Date 18 May 2020
Please ask for David Gill
Department **Planning Services**
Tel. No 01268 208250
Fax No.
E-Mail david.gill@basildon.gov.uk
My Ref: 20/00038/PREAPP
Your Ref:

119 Kenneth Road, Pitsea, Basildon

I refer to your pre-application enquiry letter received at this office 30 April 2020, in which you asked for this service's observations on a proposal to erect a three bedroom house attached to east side of the existing dwelling at the above site.

PROPOSED FRONT ELEVATION

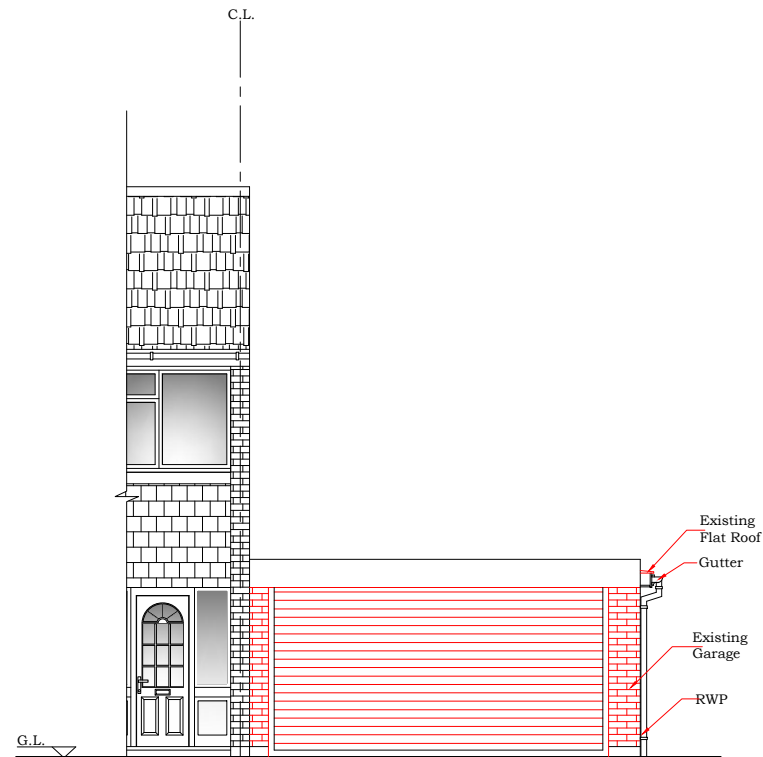
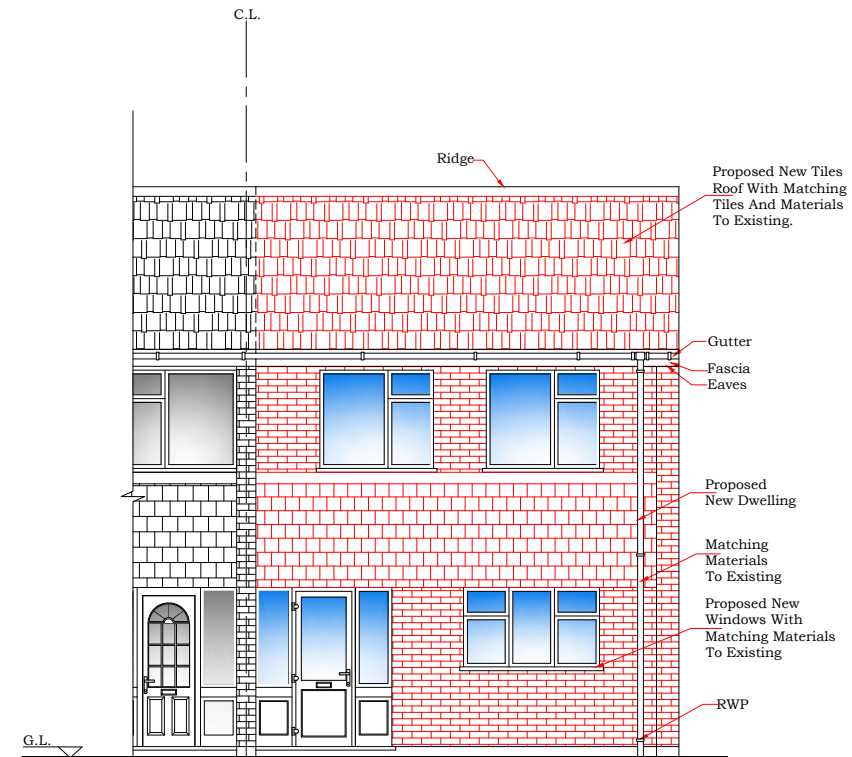
The dwelling is shown as being finished in materials closely matching that of the existing dwelling at No.119, with similar eaves and ridge levels. It is noted that the side wall of the dwelling does not project fractionally forward to mimic the projections found on dwellings on the remainder of the terrace to which it is to be attached, and this should be included if the proposal is to be progressed to the application stage.

BLOCK PLAN.

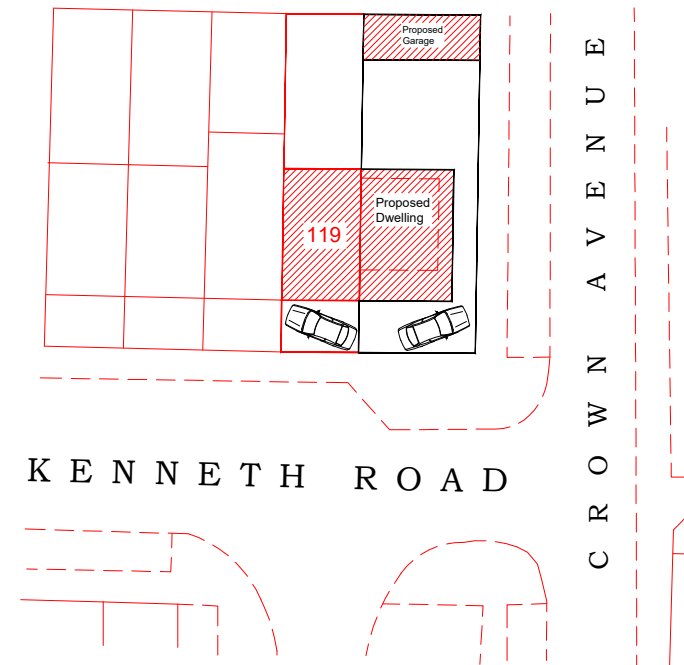
With regards to the submitted proposals, the drawings submitted show the proposed dwelling attached to the east side of the existing dwelling on this site, replacing the existing attached garage on this site, with the rear garden sub-divided to provide garden areas from both the existing and proposed dwellings. The proposed dwelling is shown with its front wall aligned with front wall of No.119, whilst the rear element includes a single storey rear projection. The dwelling would be set 1.6 metres from the eastern boundary, which would be slightly below the Council normal requirement of 2

metres on corner plots such as this, and the proposed dwelling should be reduced in width to meet this requirement.

The proposal layout shows that a good sized rear garden of around 60 square metres is to be provided for the proposed dwelling, as well as retaining a rear garden area of over 50 square metres from the existing property, and would be similar in size to that of rear gardens found in this locality, and would not therefore appear cramped.

With regards to the parking and highway issues that may be generated by the proposed development, the Council would expect that two parking spaces are provided for the proposed dwelling, as well as for the existing dwelling, given that it currently has on-site parking space and garage space, to meet the EPOA/Essex County Council Parking Standard. The proposed layout does not show any on-site parking for either the proposed or existing dwelling, and therefore would lead to parking on the highway. The site is some distance from the local town centres and railway stations of the Borough, and not within an area where the Council would normally be willing to accept a relaxation on its on-site parking requirements. As such the proposed dwelling could lead to parking on the highway, in an area that appears to suffer parking issues, and potentially lead to indiscriminate parking at the junction of Kenneth Road and Crown Avenue, to the detriment of the free flow of traffic in the locality, and the safety of other road users, and therefore would be contrary to guidance contained in the NPPF and policies of the Local Plan.

It is therefore considered that the proposed erection of a house on this site, due to its lack of parking provision, would not comply with the above mentioned policy contained in the Local Plan, and as such would have a detrimental impact to the amenities of this area, and as a result such a proposal would be viewed unfavourably by this service.
